EAST PRESTON PARISH COUNCIL

Re: recent planning documents

I would like to use Planning Application EP/48/21/HH as an example of the concerns the committee has. This Application was for 2 Bay Tree Garden, one of a cul-de-sac of just three properties.

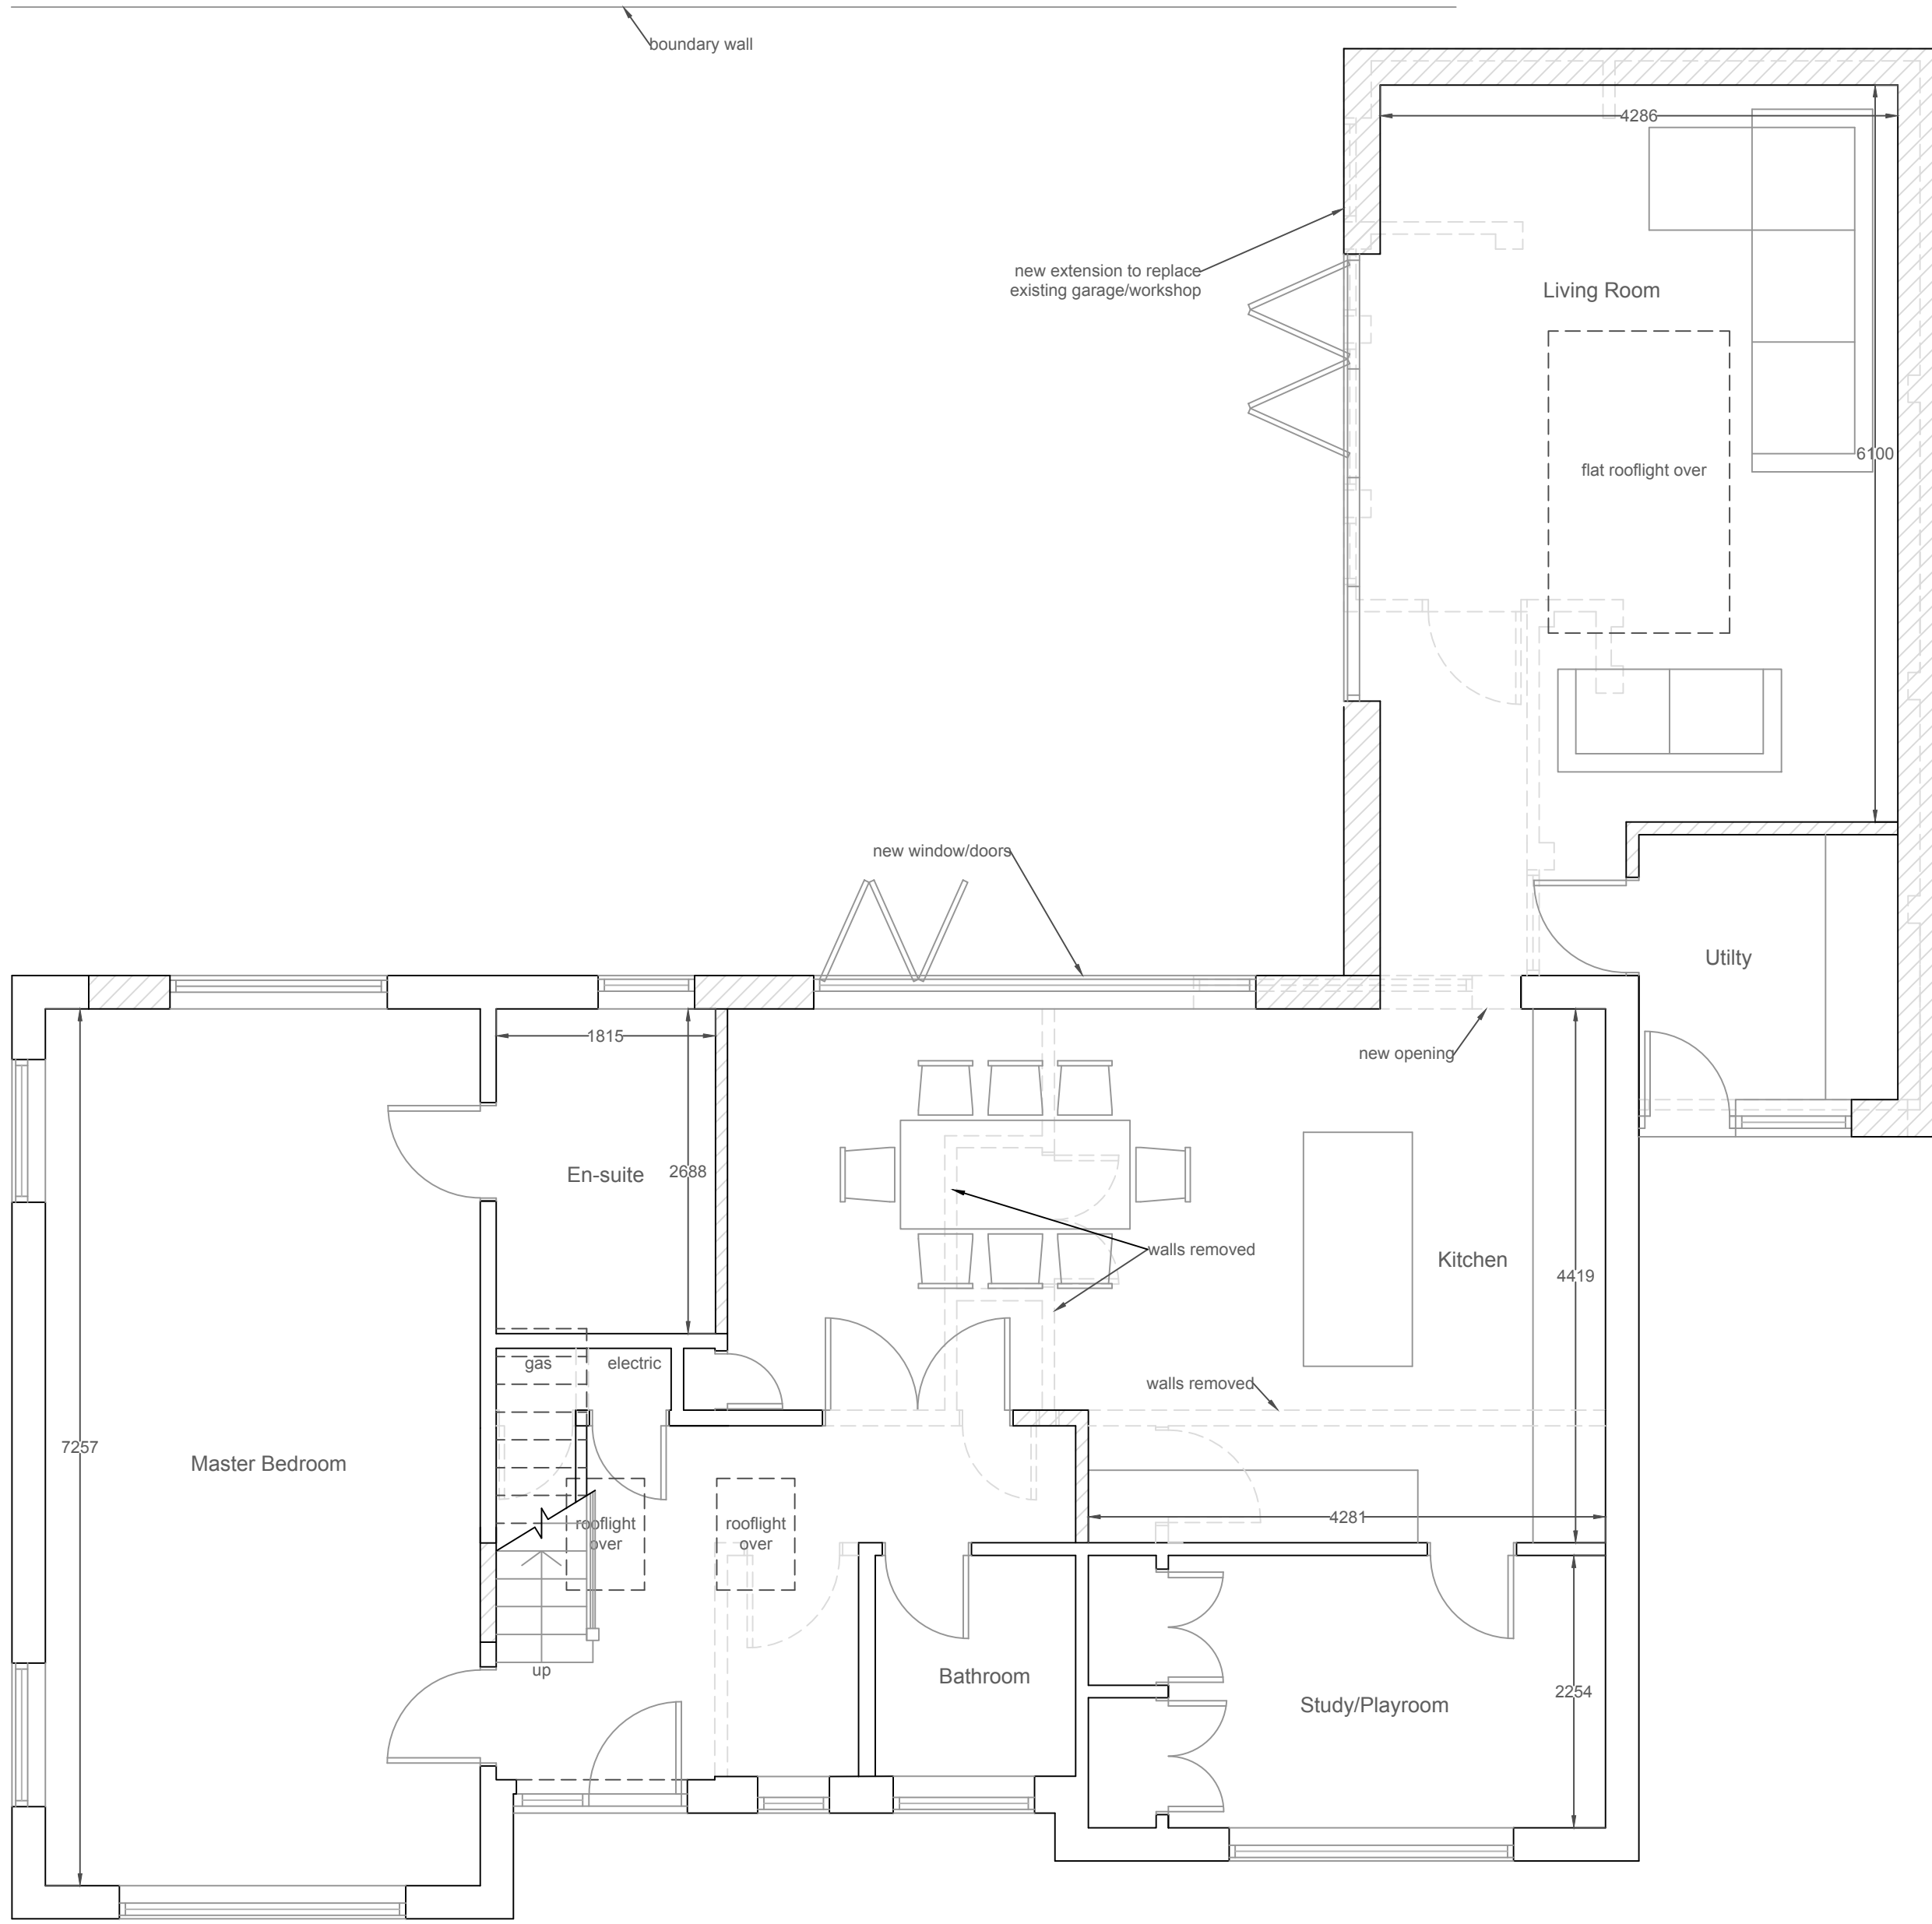
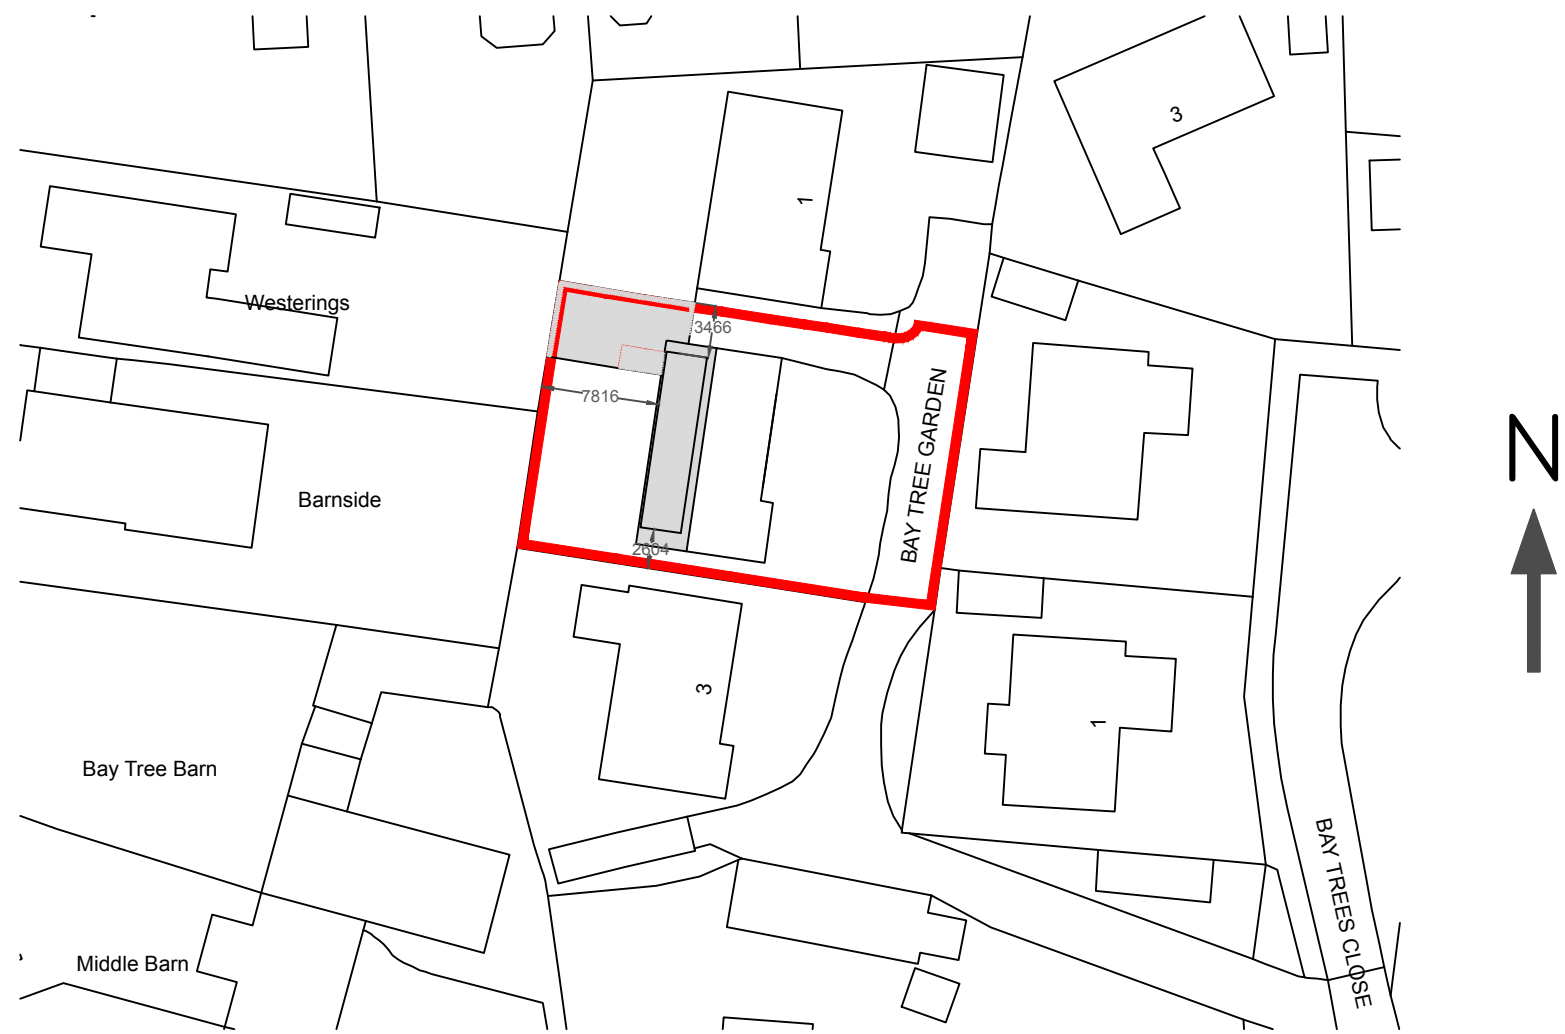
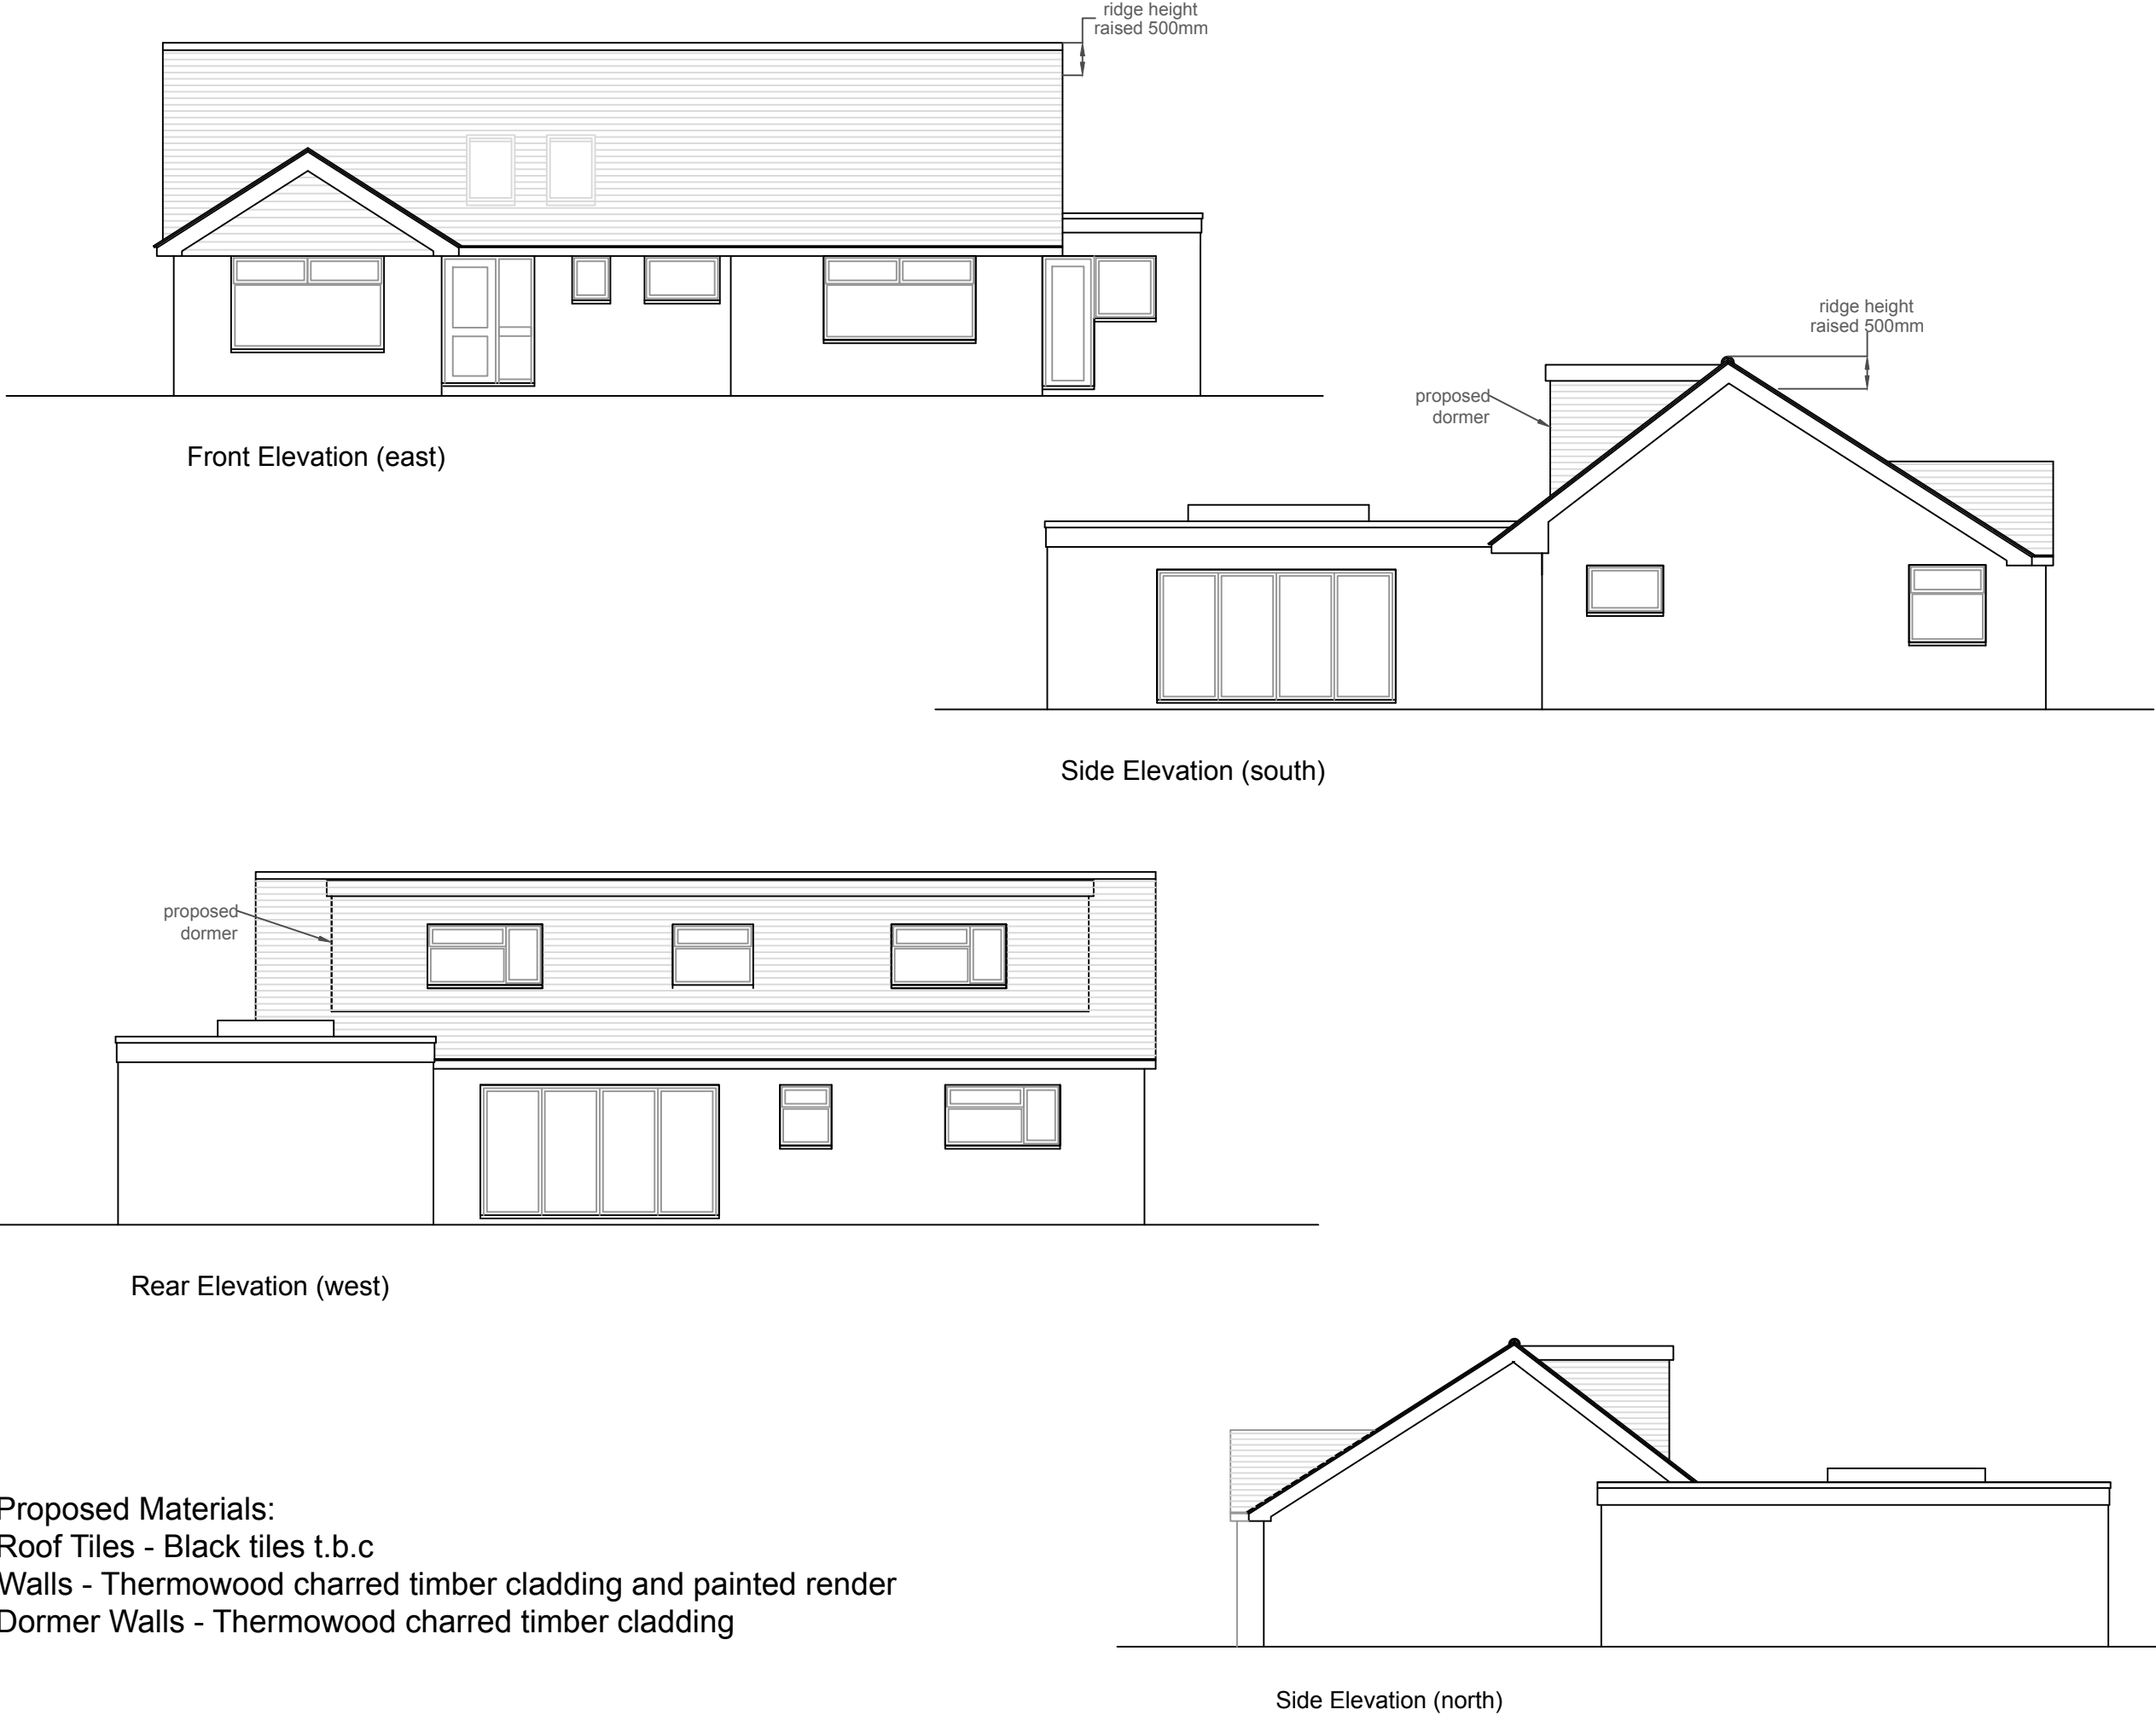
Starting with the Decision Notice, there is one item of especial concern. Condition 3 reads, "The dormer windows in the rear elevation of the dwelling for bathroom and two bedroom windows shall be glazed with obscured glass and non-opening above 1.7m." Unless we are very much misinterpreting this, these windows should be non-opening **BELOW** 1.7m, shouldn't they? In other decisions notices making this same point, the wording has indeed been "below 1.7m".

The Officer's response to the objection to materials was "Materials proposed (roof tiles) to match with host dwelling/ timber cladding is common material used for dormer extensions." This does not address the objections made, in that these materials, being a complete change from the original ones, would change the appearance of the house completely and would not therefore fit in with its neighbours in this tiny close.
